CITY OF ALBUQUERQUE

**Re: US Eagle Credit Union- Menaul
7201 Menaul Blvd. NE
30-Day Temporary Certificate of Occupancy
Transportation Development Final Inspection
Engineer's Stamp dated 1-18-21 (H19-D090)
Certification dated 12-15-21**

Prior to the issuance of a permanent Certificate of Occupancy, the following items must be addressed:

Sheet No.
C-100

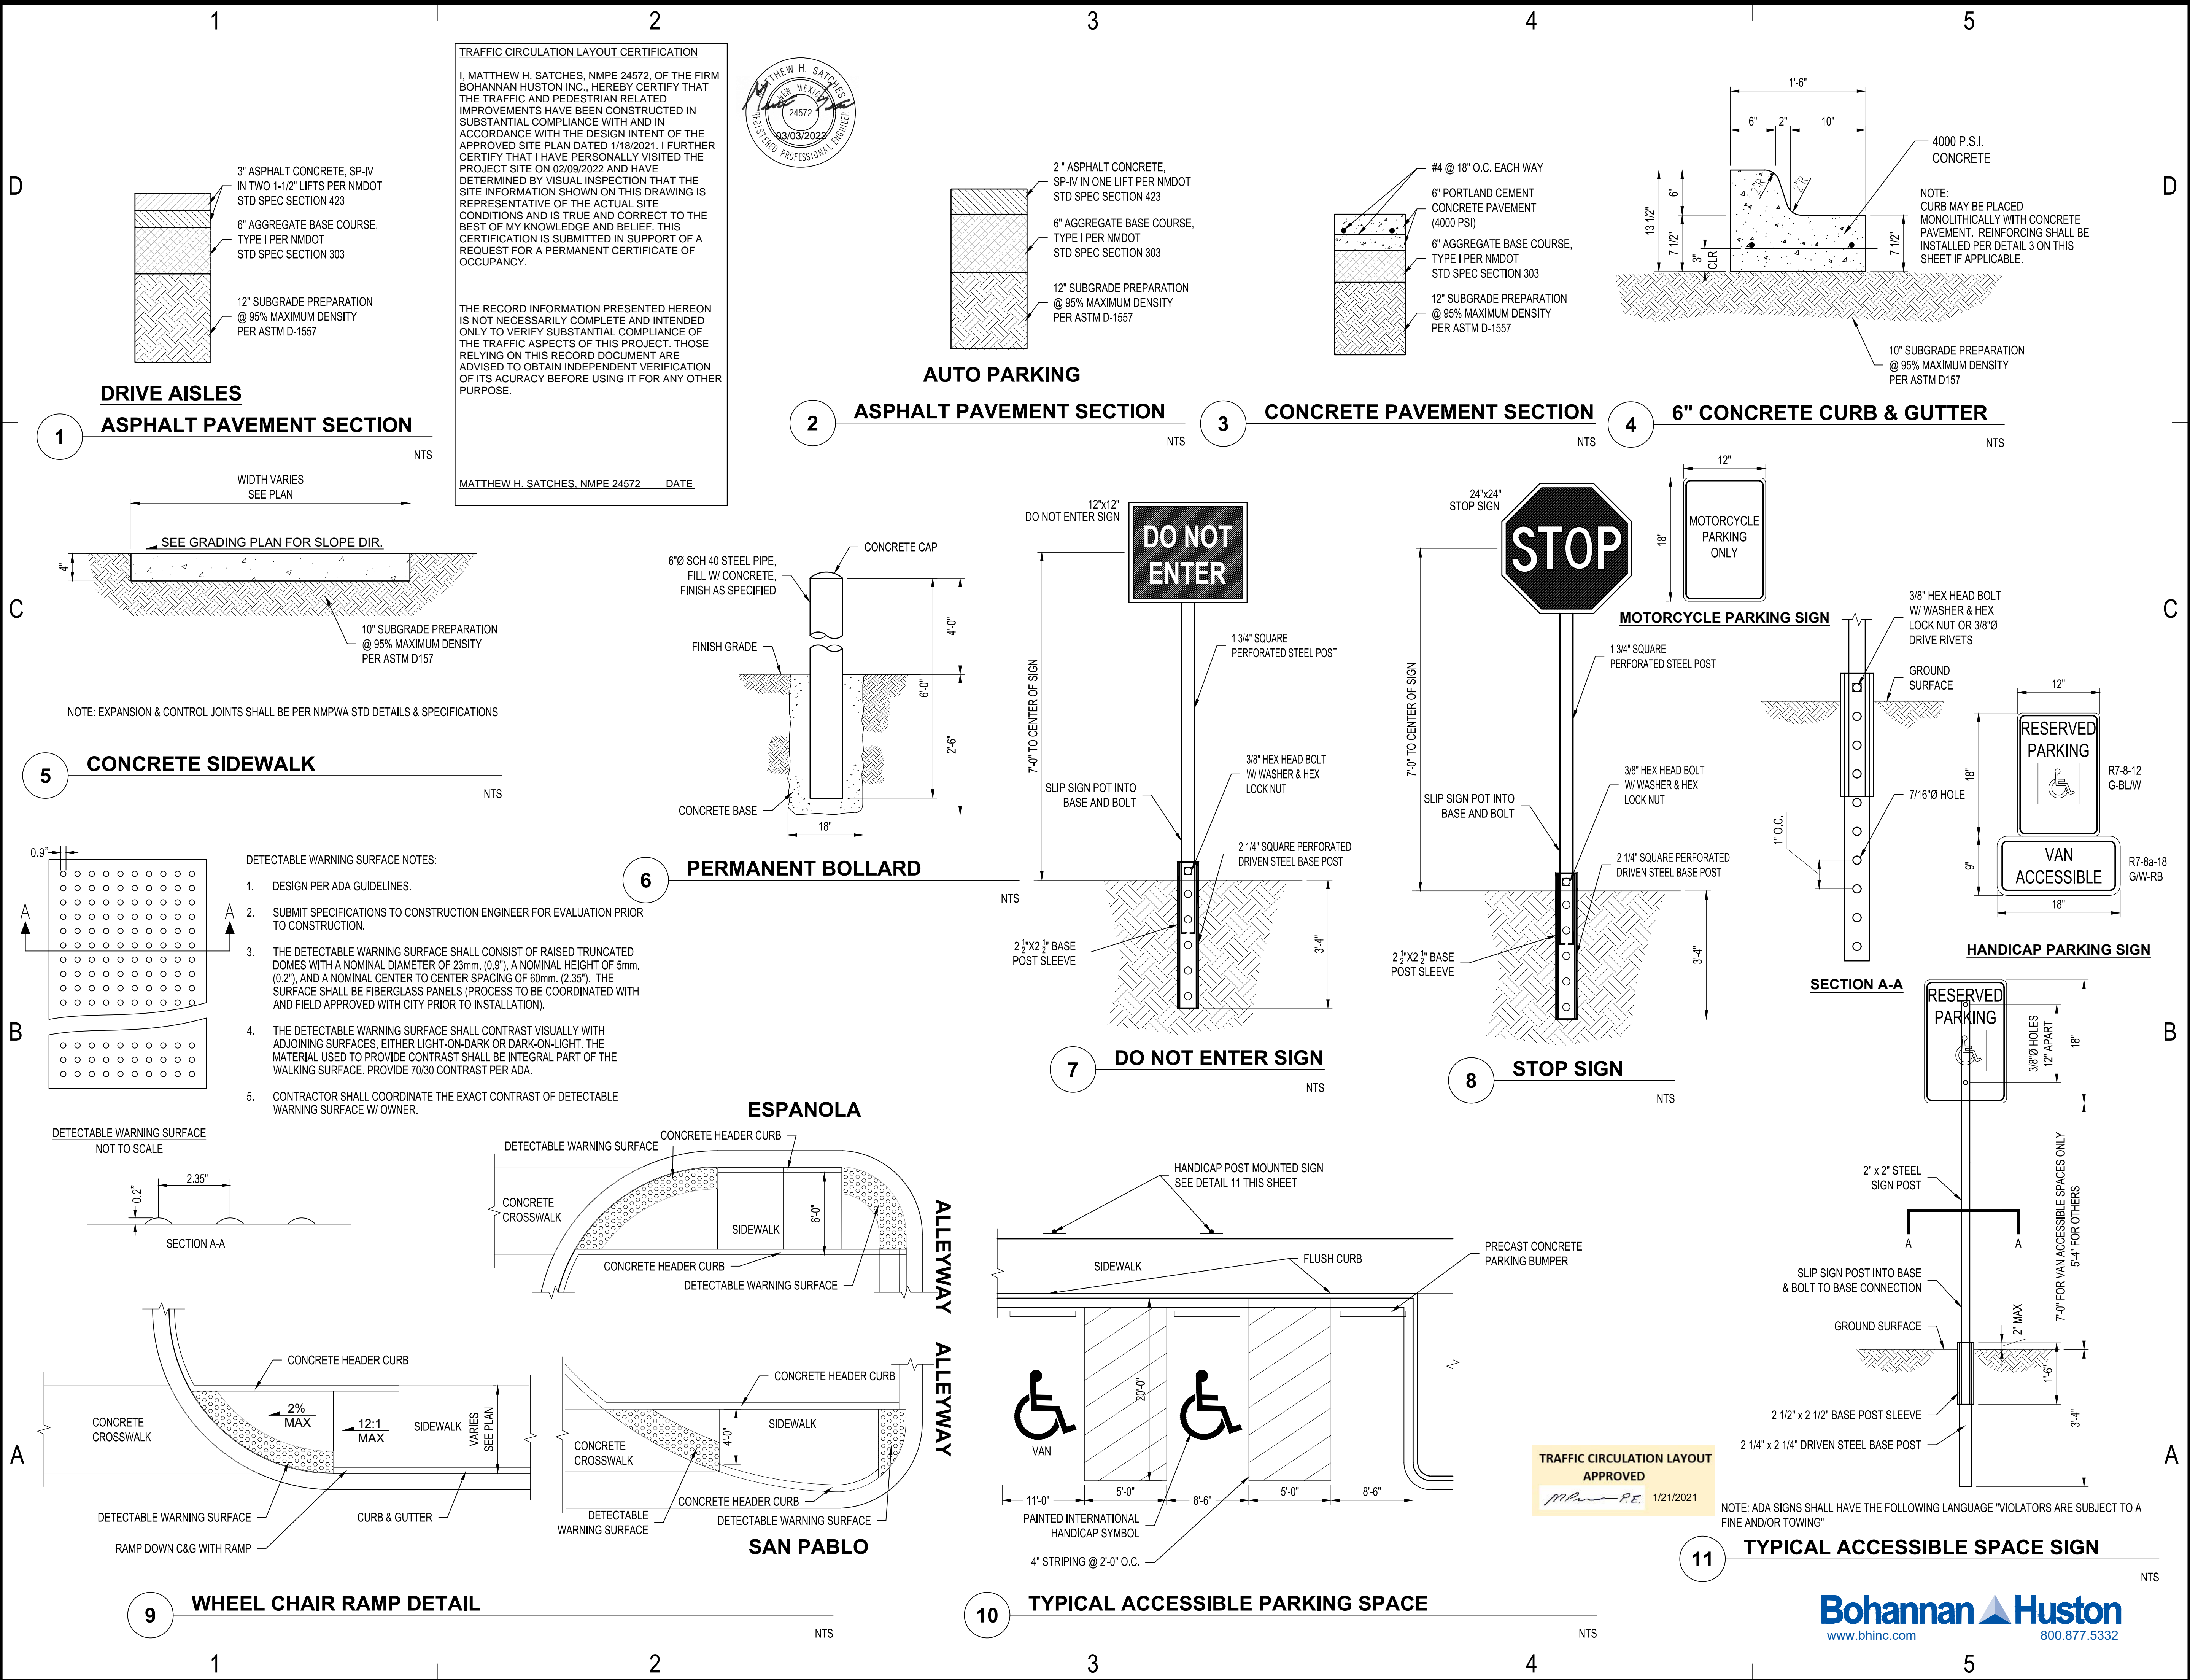
- **Safety Issue:** There is a **Hole** between parking spaces and the sidewalk off Menaul, and **Power lines** exposed. Please address this concern.
- DO NOT ENTER signs and DO NOT ENTER pavement marking need to be placed inside private property.
- Provide VAN ADA Parking space and VAN ADA accessible Aisle. Van accessible aisles should be 8ft wide.
- Remove construction equipment and debris from site.

Once these corrections are complete, email pictures & redlined TCL plan showing the changes to malnajjra@cabq.gov for release of Final CO.
